## **Road restrictions**

## **Pedestrian Underpass**

**Have any details of the proposed upgrading of the underpass at High St been prepared?**

## **Accessibility**

Do not scale from this drawing.

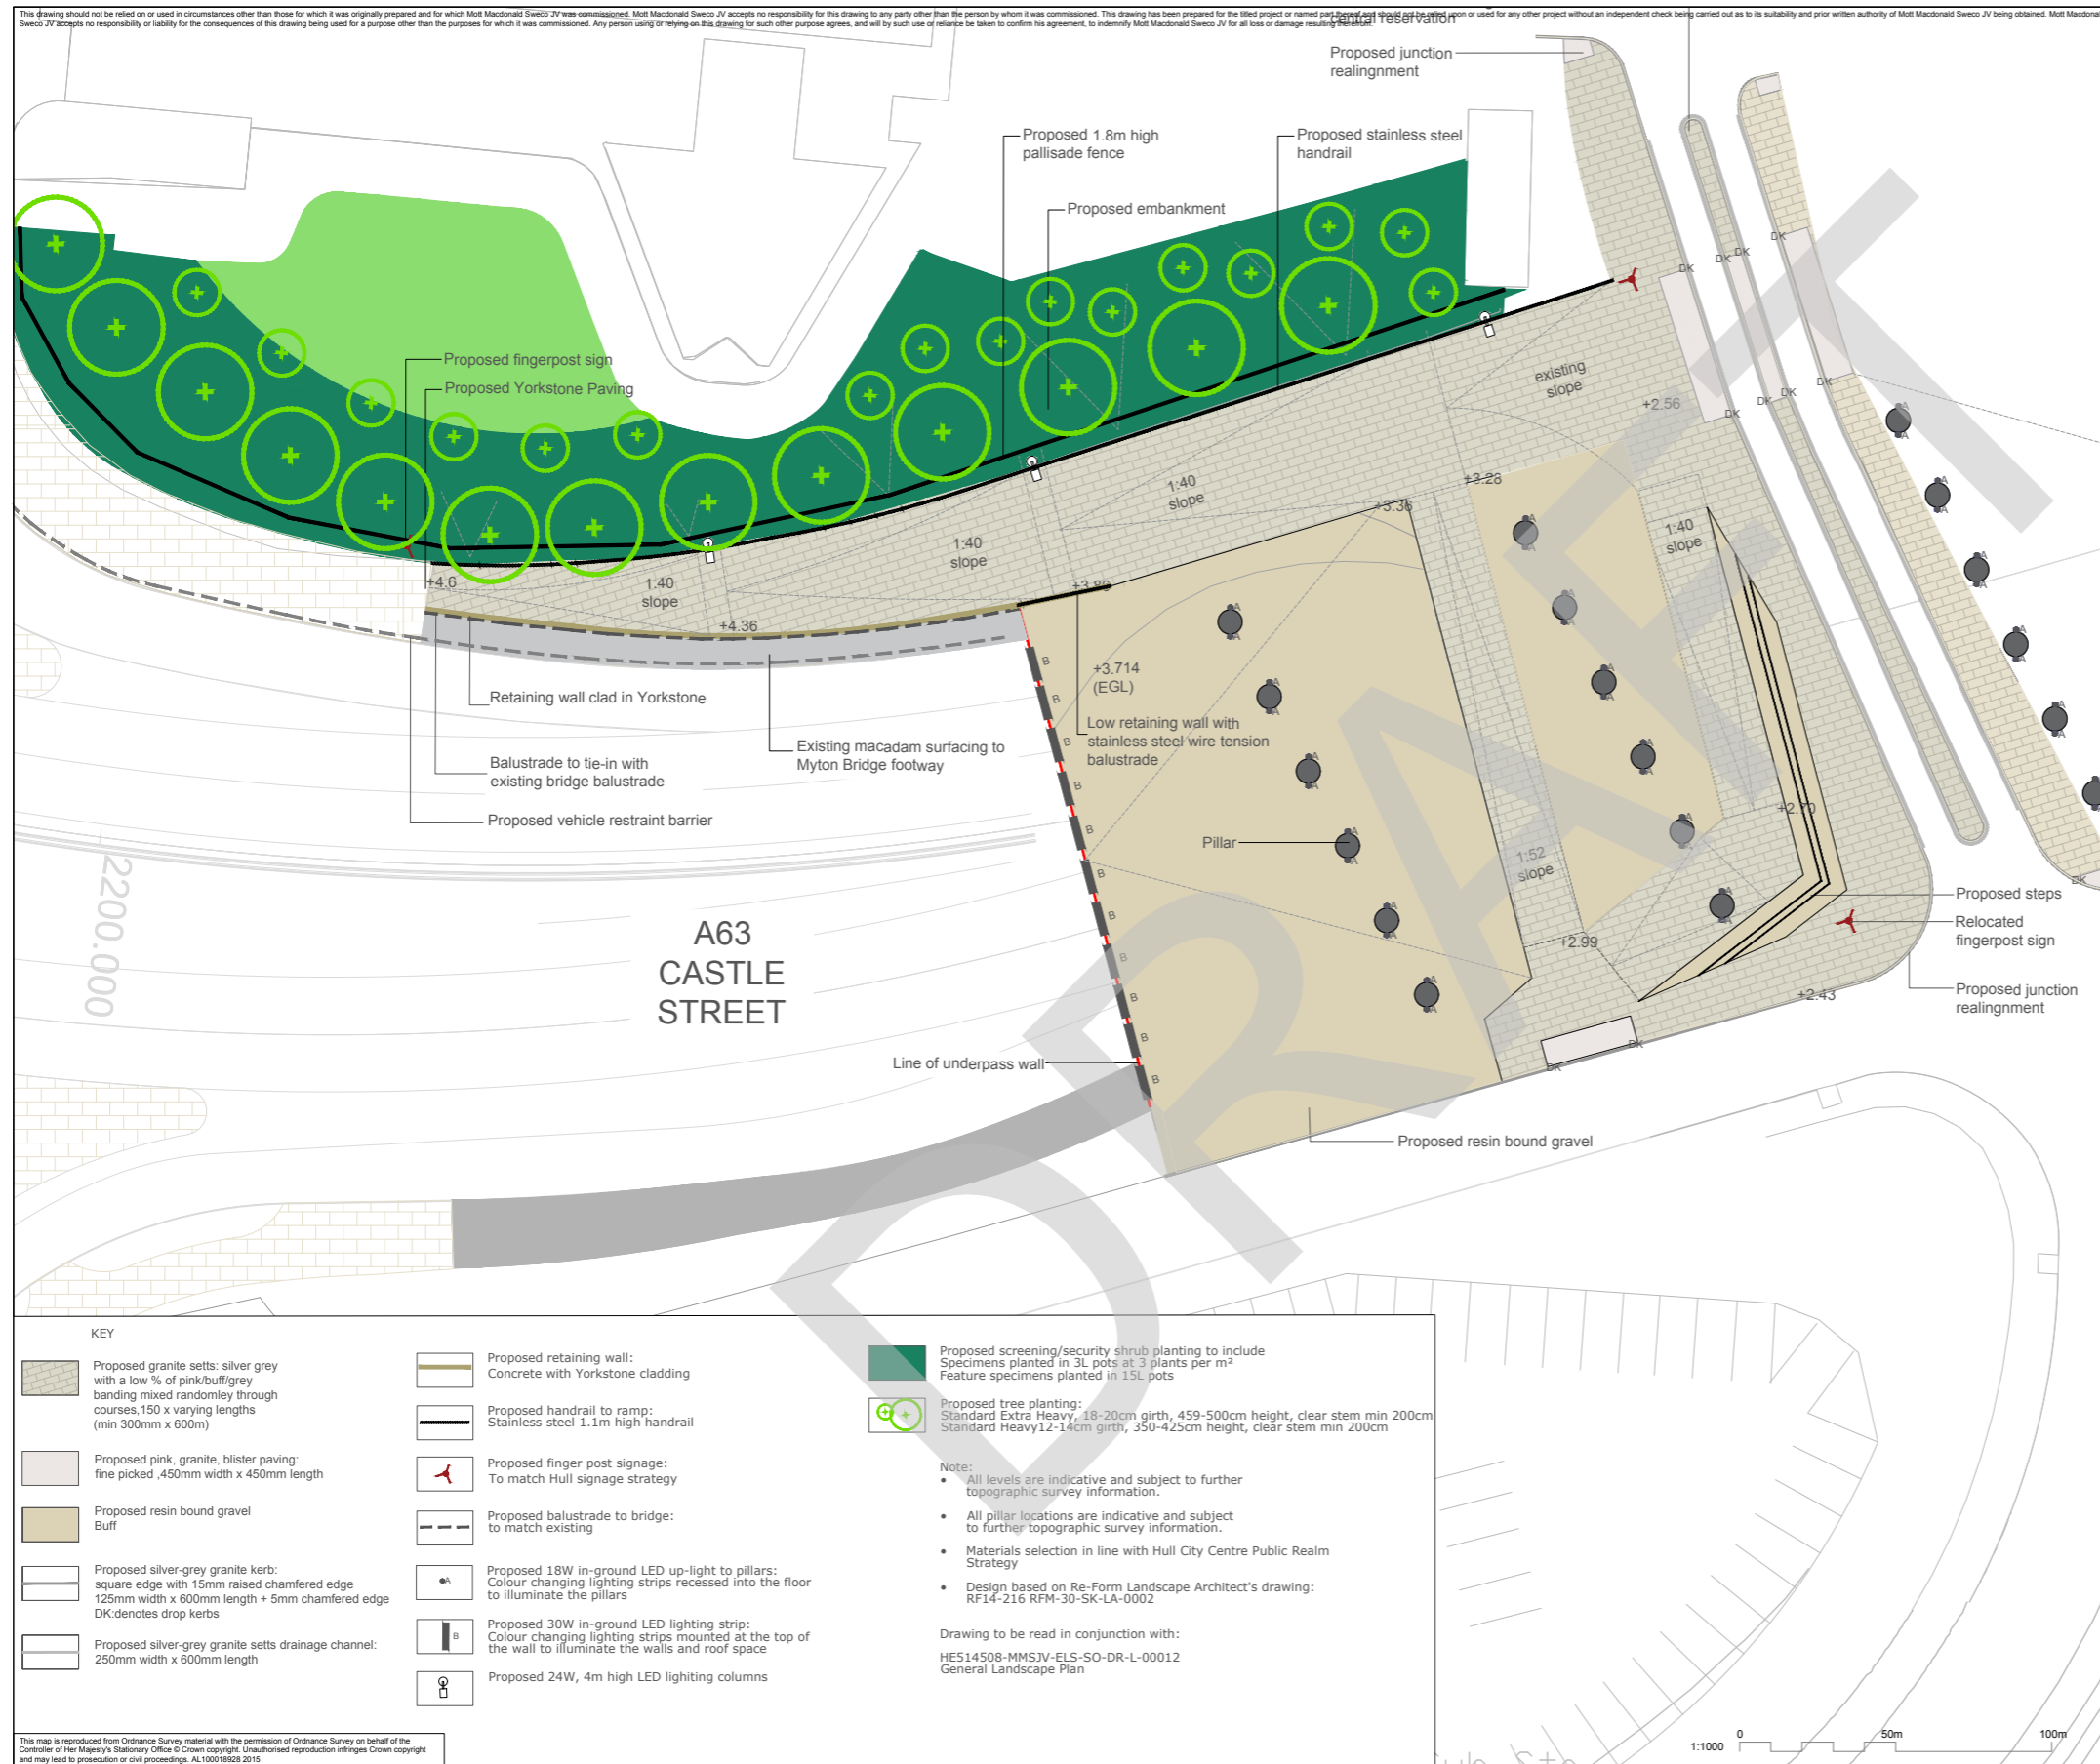
HAIG have been consulted on the proposed works and made suggestions to improve access. Meetings have been positive with the designers and Highways England engaging in constructive dialogue.

Looking at the design in isolation it works. But it cannot be looked at in isolation, it has to be seen in context of Castle Street and the travel distances involved by people using this route or the main bridge with its long ramps. Providing lifts to the main bridge must be added to the scheme to help reduce the travel distances.
